Recommendation Report for Planning Permission for Works or Extension to a Dwelling

REF NO: FP/233/20/HH

LOCATION: 9 Wansford Way
Felpham
PO22 7NL

PROPOSAL: Single storey rear extension, first floor side extension and conversion of roofspace to habitable use and dormer.

Proposed Ground Floor Plan

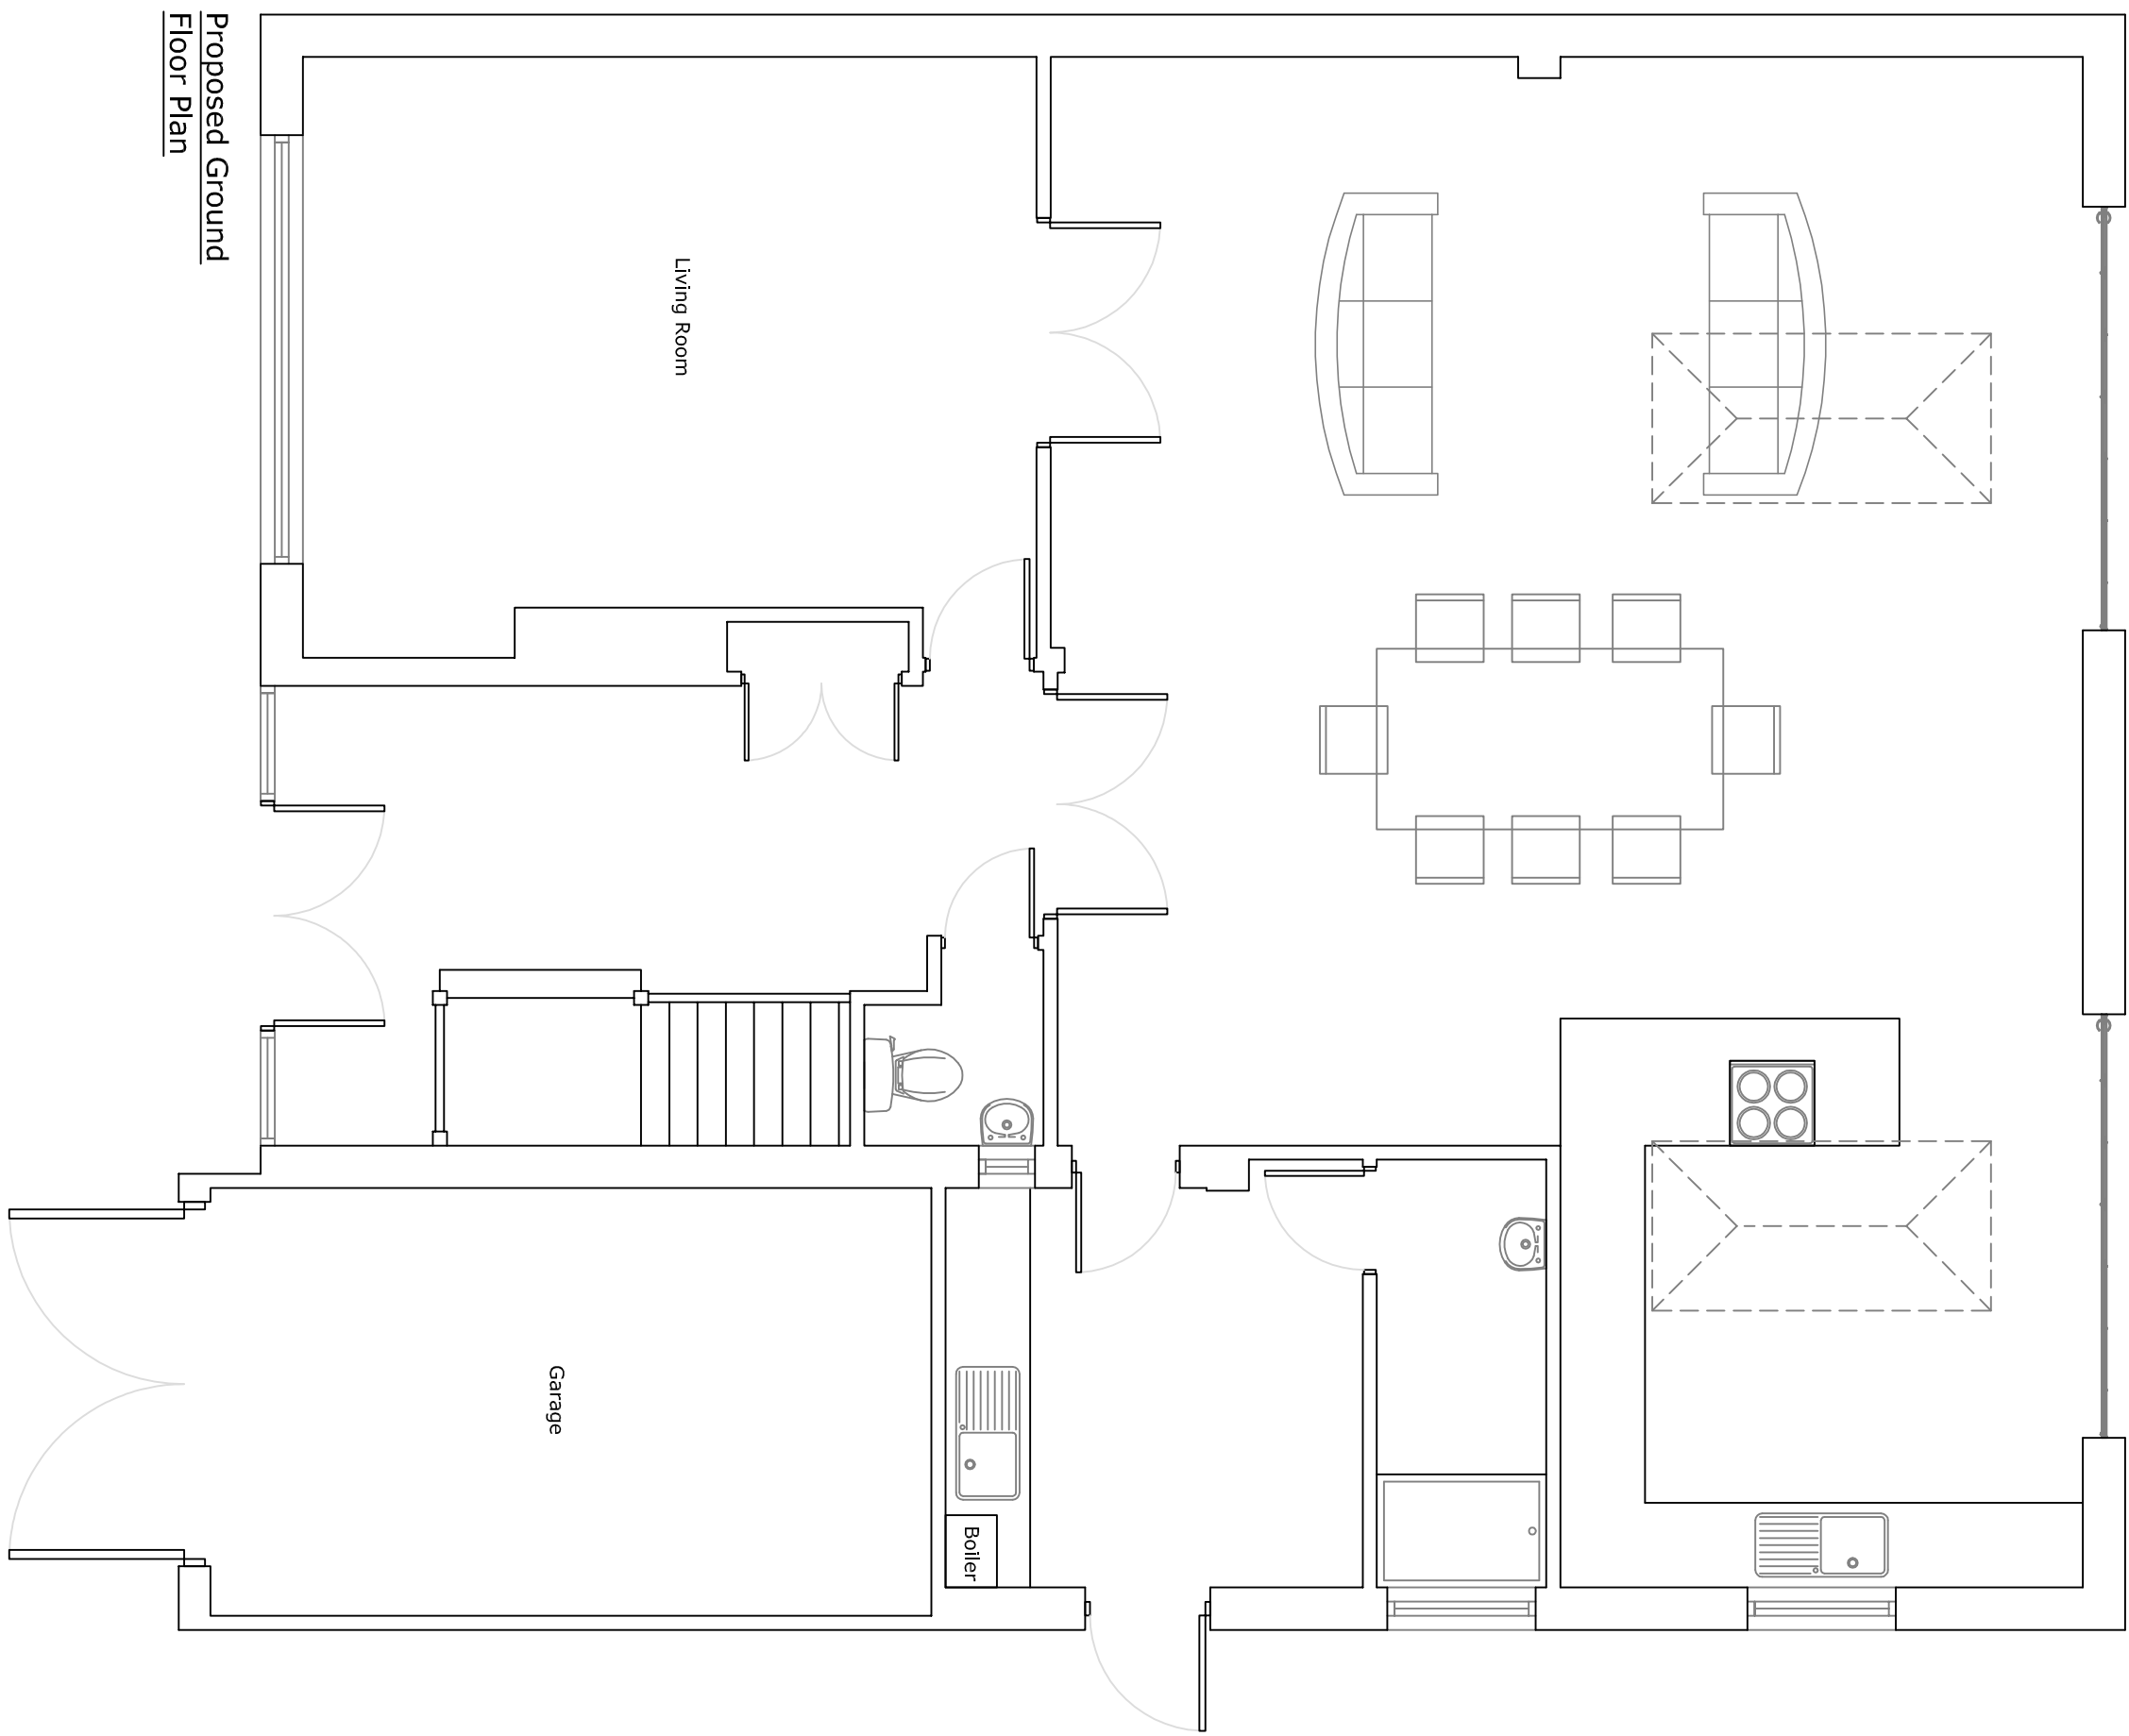
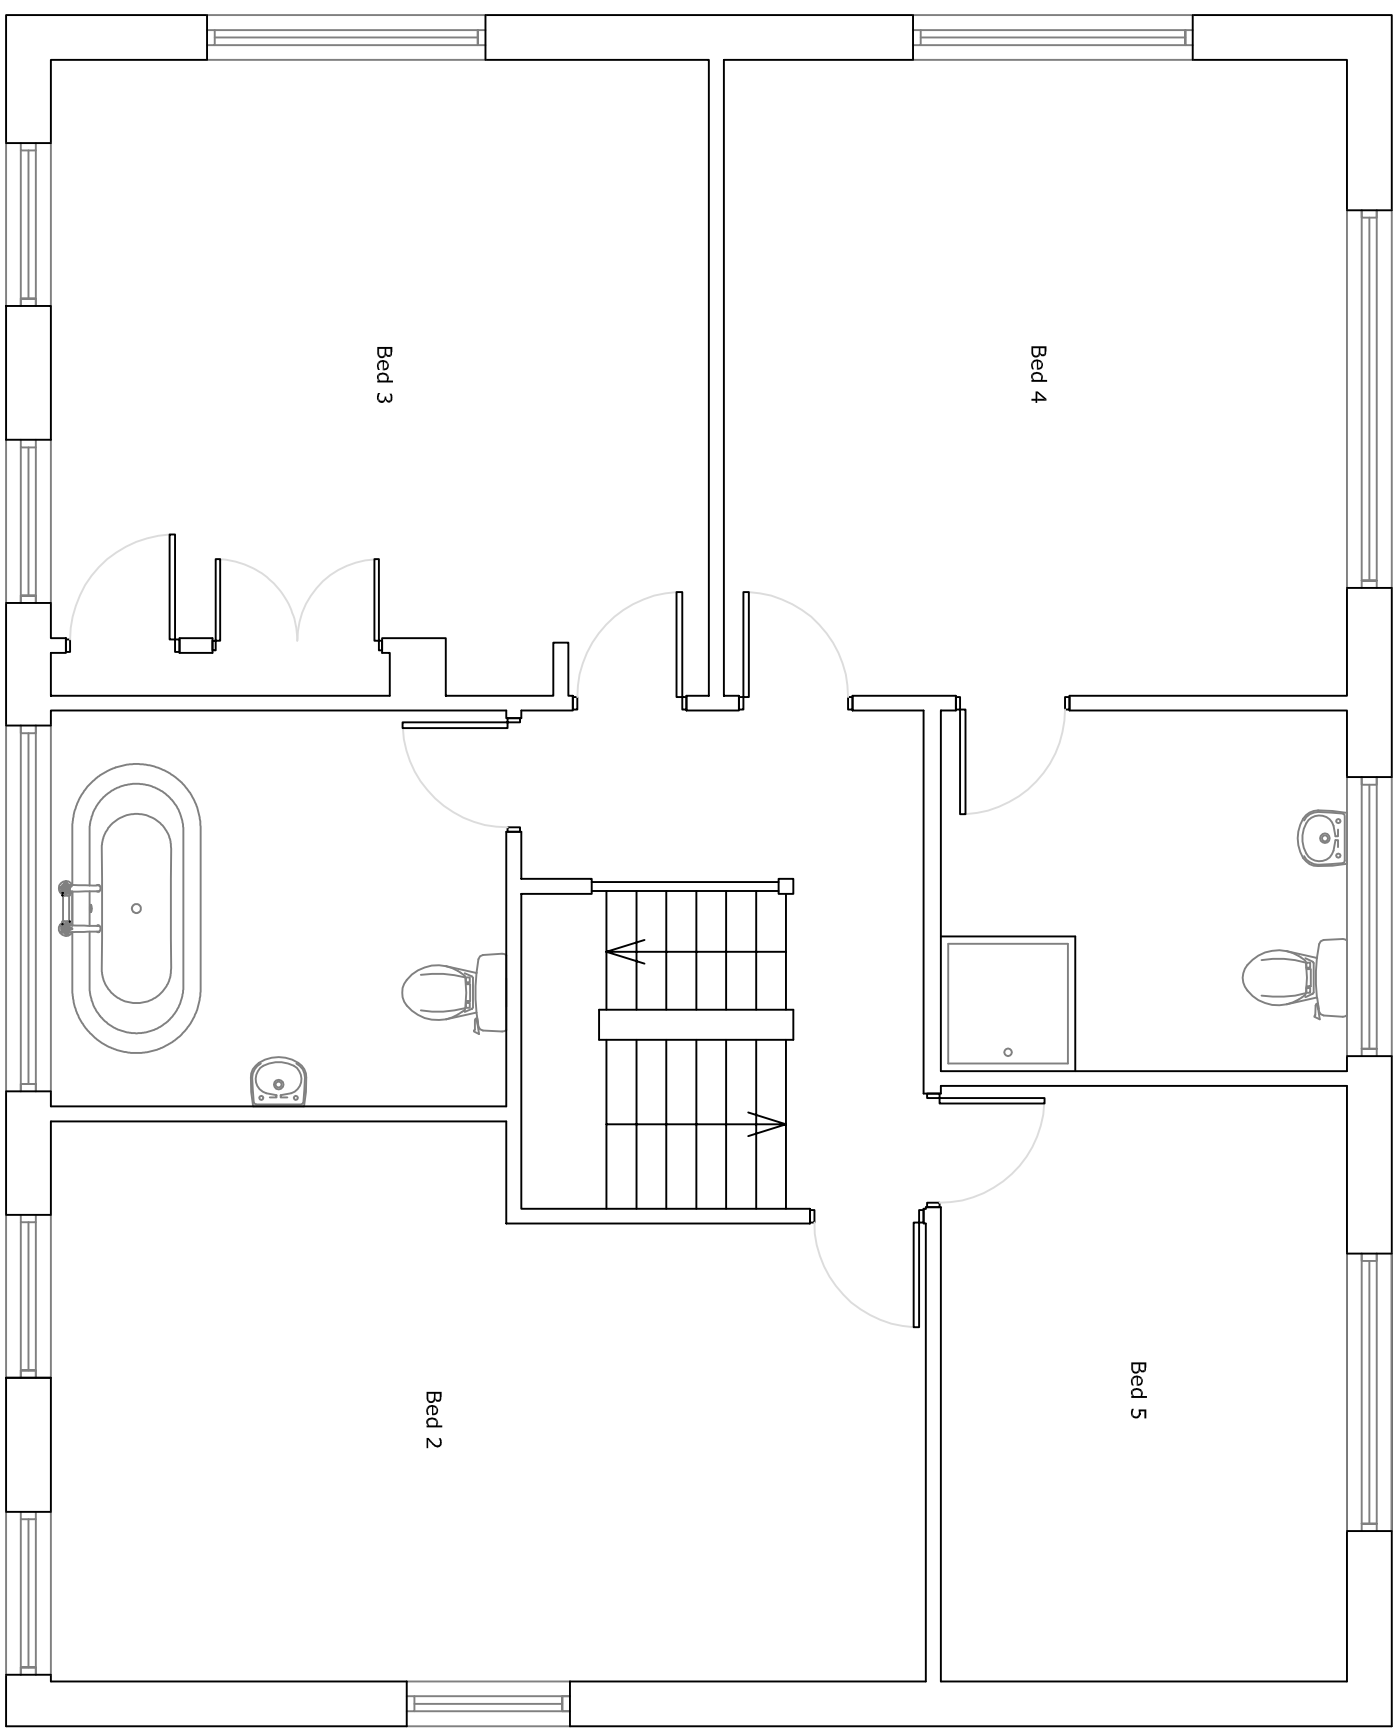
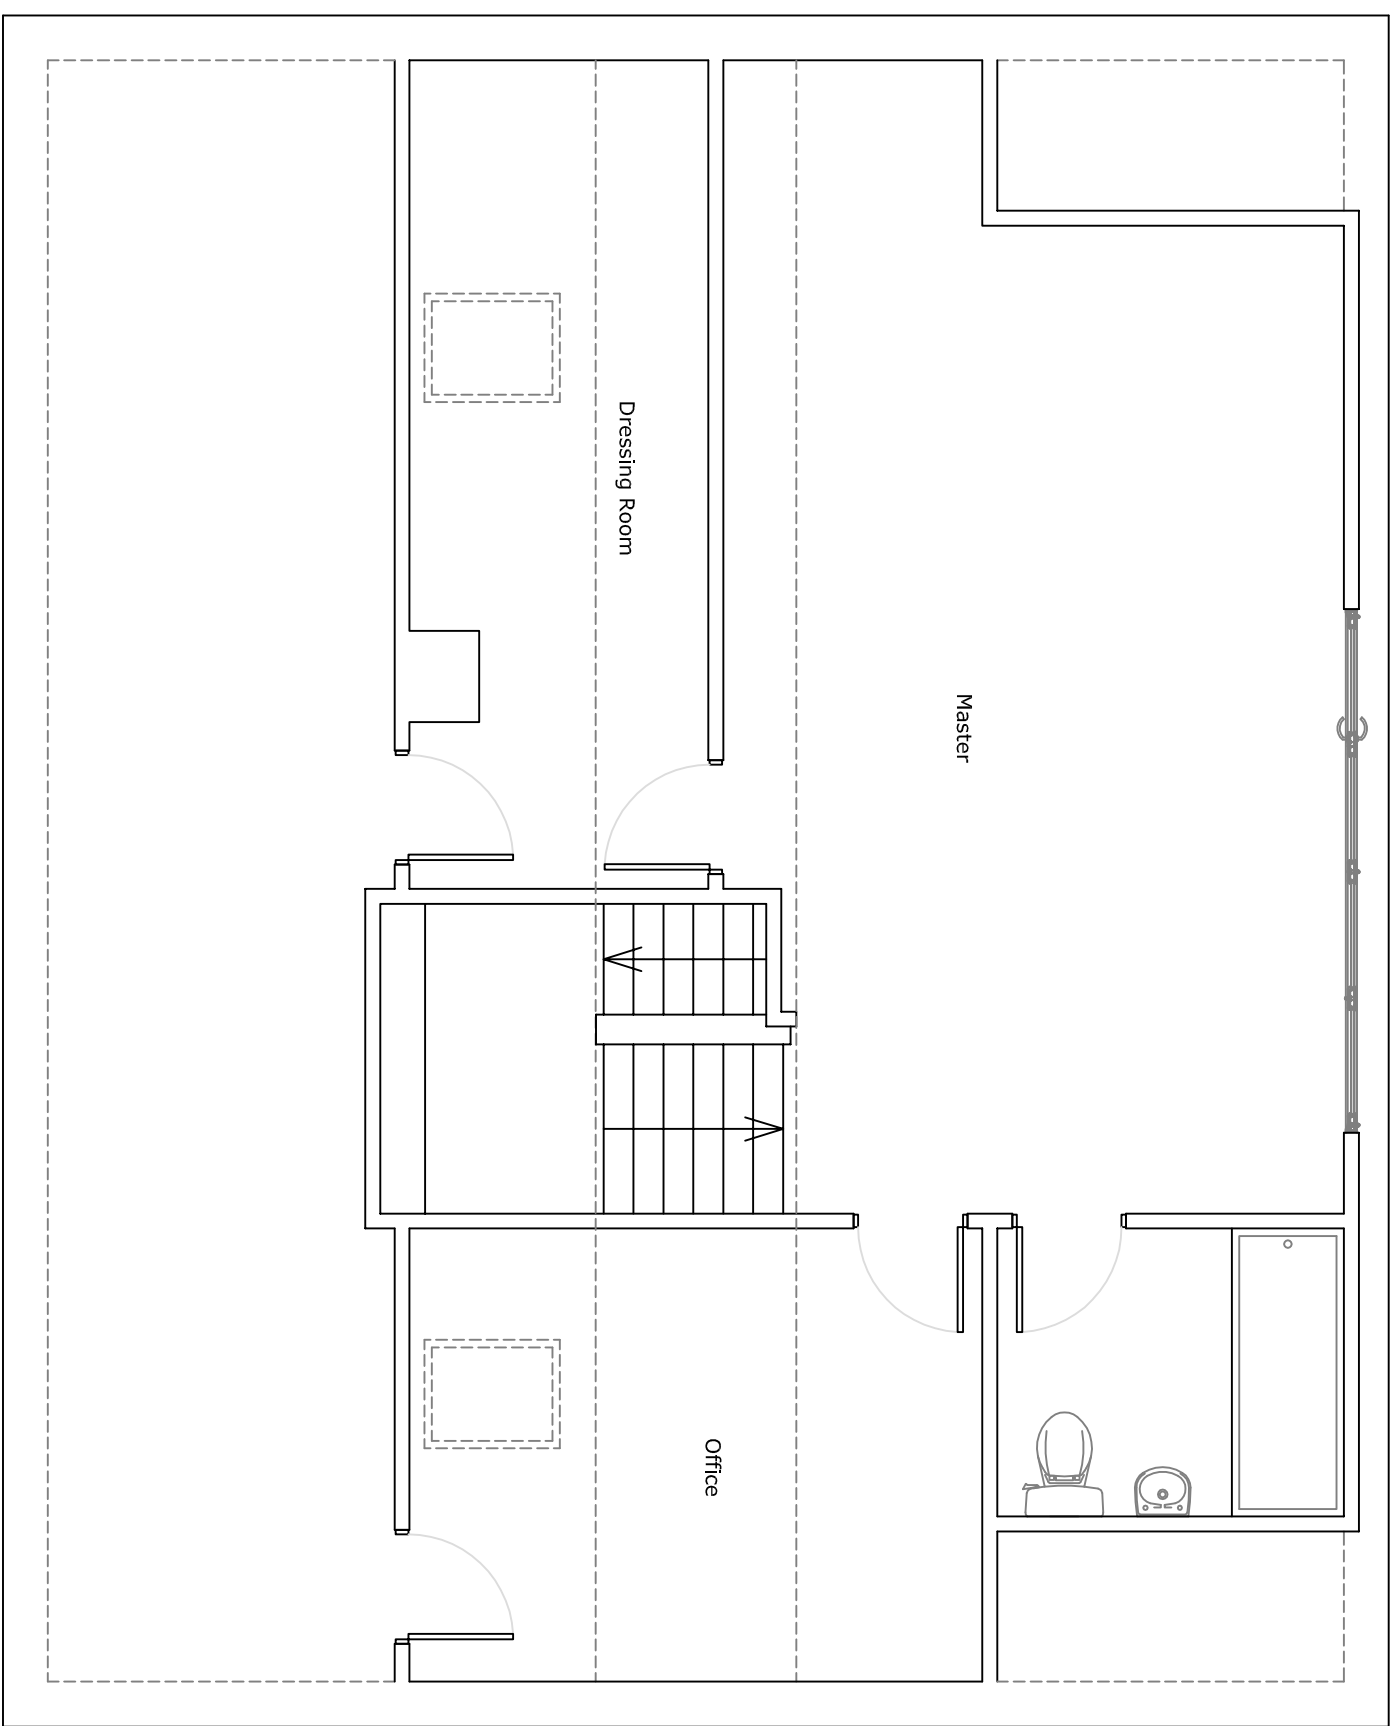
The first floor side addition will be sited to the northern elevation. This will extend in depth to meet with the existing rear elevation. There are some first floor windows to the side elevation of No.11 and as such these may have some minor loss of light due to the first floor addition being sited forward of these. However, this is not considered to be significant with over 1m retained to the boundary.

There is an existing conservatory to the rear elevation however this will be removed and the extension will run along the full rear. The rear extension will have a depth of around 3.8m and a flat roof height of 2.75m which increases to 3.15m with the addition of 2 rooflights.

There will also be a dormer to the rear elevation. This will have a depth of 3.6m and a height of 2.6m and will run along the rear roof slope retaining approximately 1.3m to both sides. This will have a juliet balcony again overlooking the rear. Whilst this will give rise to views that aren't currently achievable, although with no properties directly to the rear, views are not considered significant.

There will be an additional window to the first floor rear however due to the siting, views are not considered to increase from that which are already available from the existing rear facing windows and as such is not considered to give rise to additional adverse overlooking. There will be doors to the ground floor extension, although these will open onto the garden of the host dwelling.
